From: White, Lori (ECY) <lowh461@ECY.WA.GOV>
Sent: Friday, February 08, 2019 2:10 PM
To: Chelsea Benner
Subject: RE: Shoreline permit for the Ball residence

So I looked over the report and application. The report is a little confusing but I believe she is implying the OHWM is located near the base of the bluff, such as the water line located on aerial image dated 7/13/2017.

Figure 7. Ball Property, Shoreline Map

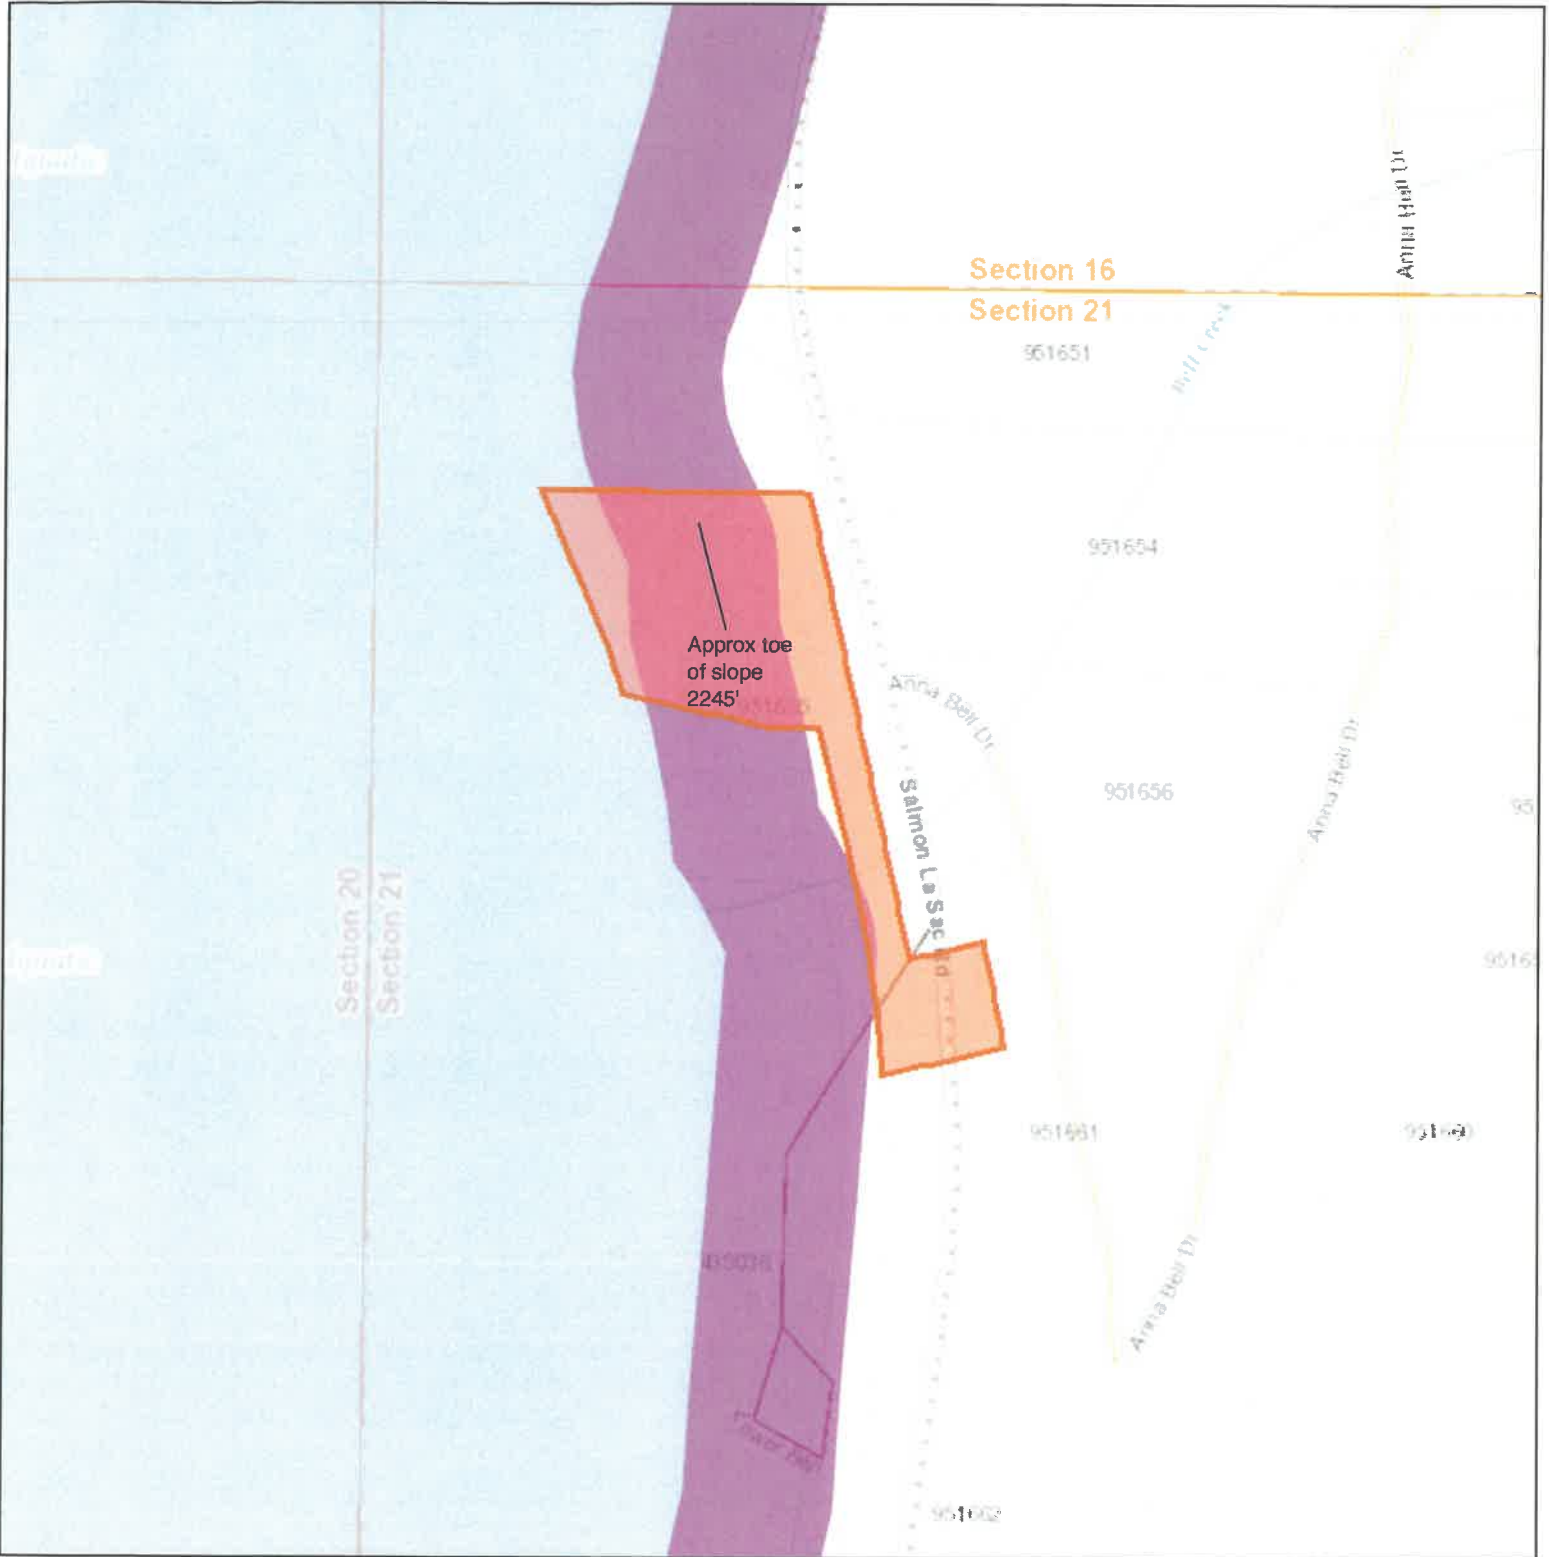
If this is the case, based on the information provided in the report, Lidar images, and historical aerial images I would agree that the line is located either at or near the base of the bluff. There are clean cobbles /sand and sparse vegetation landward of the bluff, which are geodic indicators we use. The scarp represents the mark created by the presence and action of waters. The nearby upland vegetation is distinct, with a persistent line of perennial vegetation (biologic indicators). This would make the majority of the parcel within shoreline jurisdiction.
